**Response to Submissions – Nulon Motor Oils Facility,  
Bringelly Road Business Hub (SSD 8900)**

Thank you for your email on 21 May 2018 requesting Transport for NSW (TfNSW) to provide comment on the Applicant's Response to Submissions (RtS) for the proposed development of the Nulon Motor Oils Facility, located at Lot 10 DP 29104 within the Bringelly Road Business Hub.

DRAWING TITLE
SITE PLAN

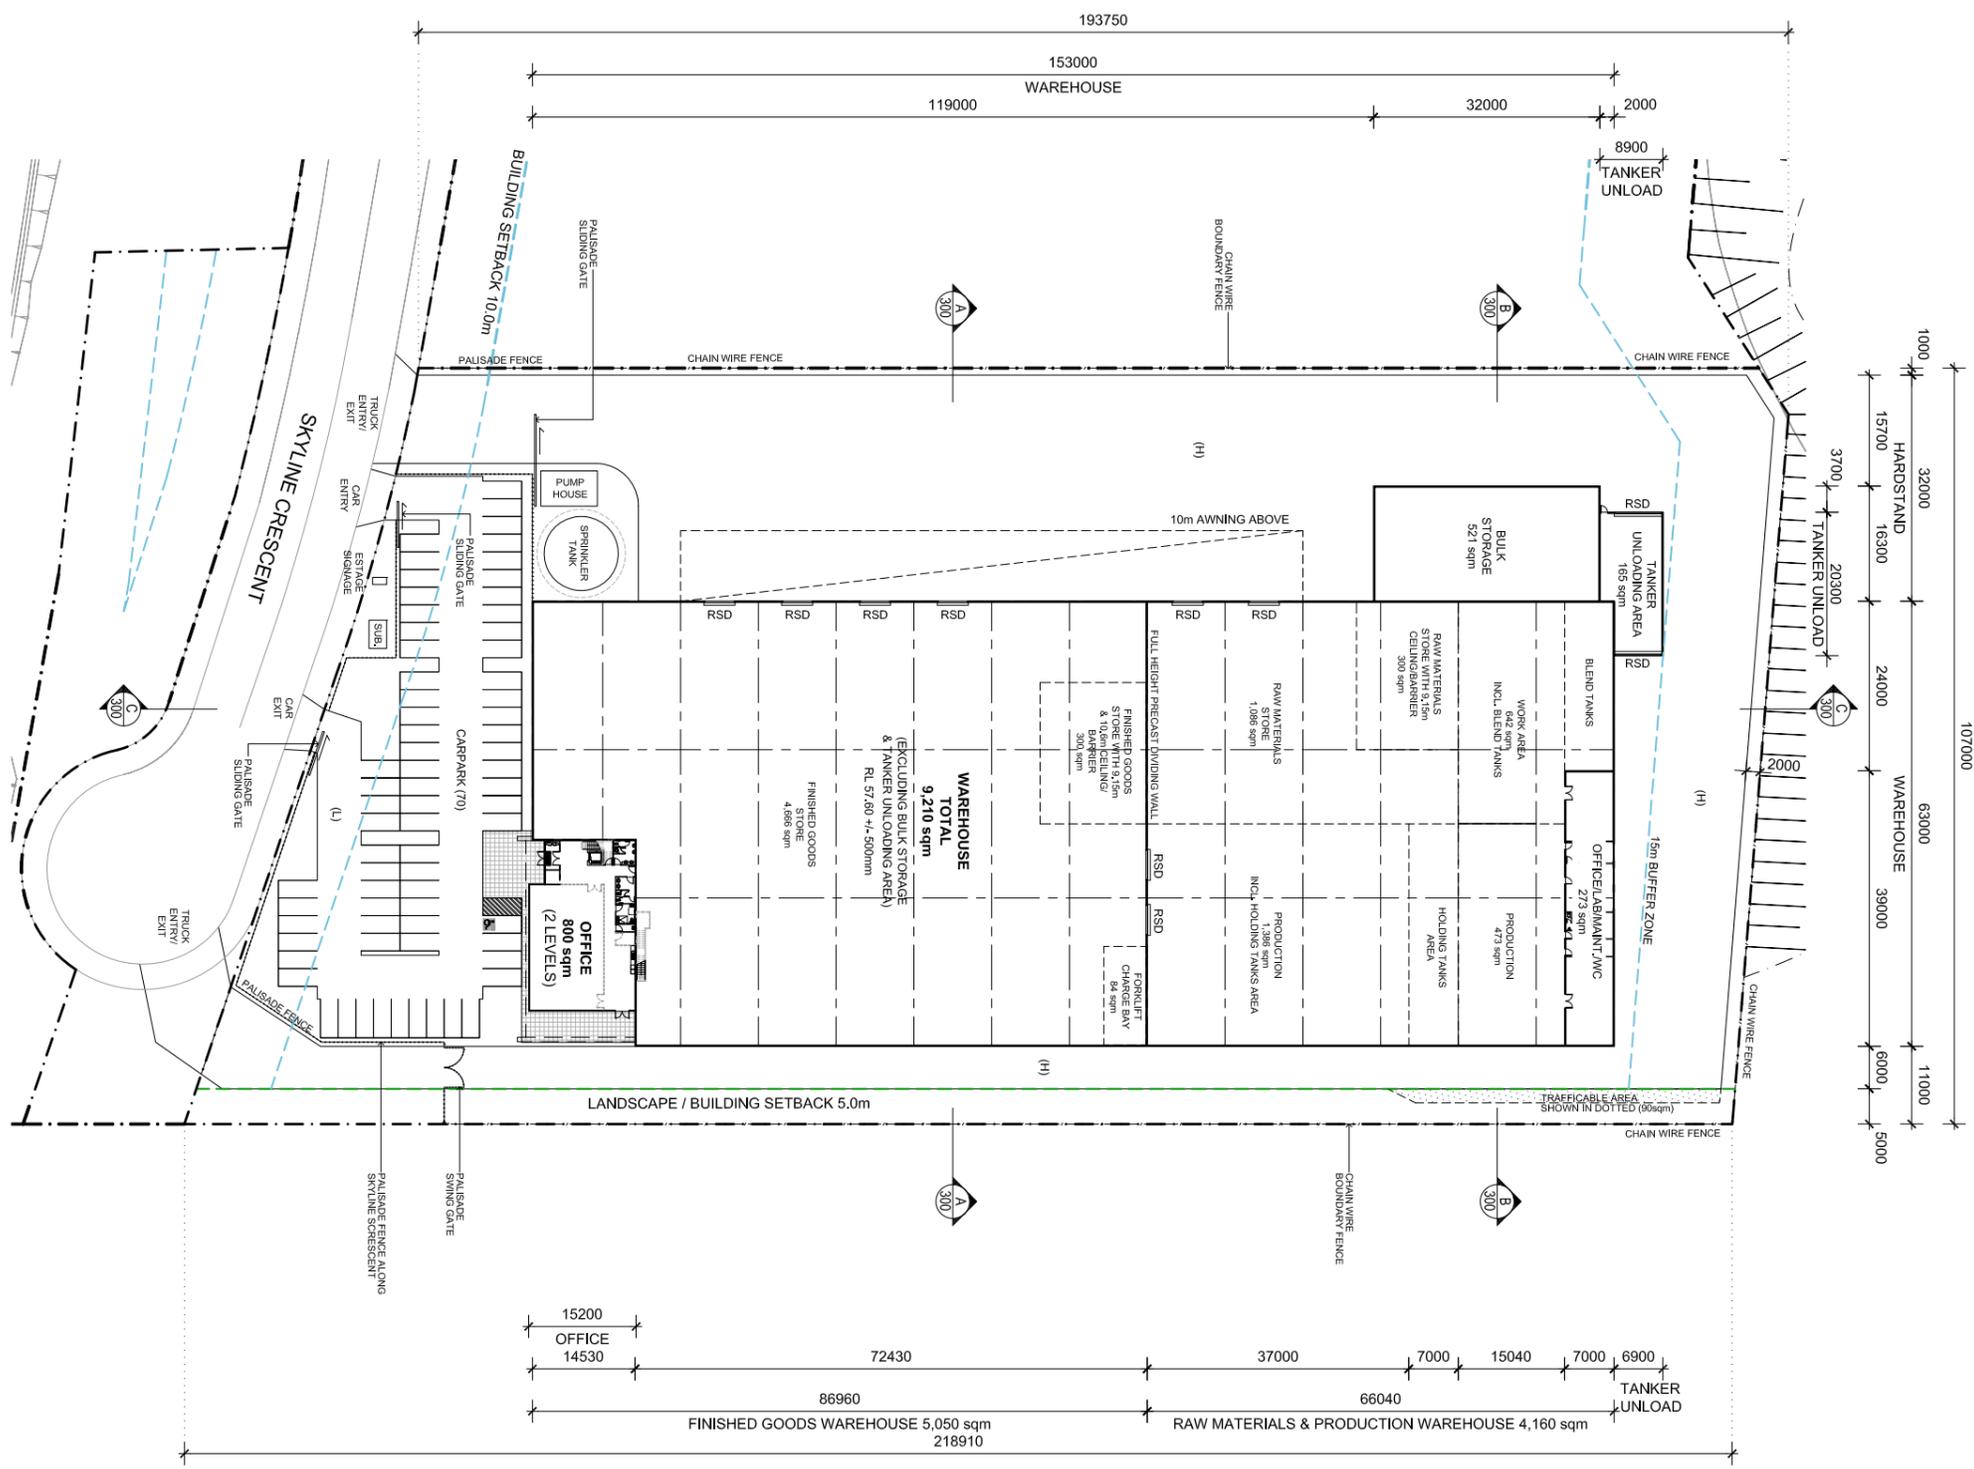
Although the Applicant has indicated a nominal area for bicycle parking adjacent to the office entrance, it is unclear how many bicycle parking spaces could be provided. The *Cycling Aspects of Austroads Guides* recommends a bicycle parking provision of 1 space per 1,000sqm GFA for light industry uses. Therefore, the Department of Planning & Environment should include the following conditions of consent to ensure a suitable provision of bicycle parking and assist in achieving the objectives of the Sustainable Travel Plan:

- A total of 10 bicycle parking spaces are to be provided within the development. These spaces must be designed and provided in accordance with *AS2890.3:2015 Bicycle parking facilities*.
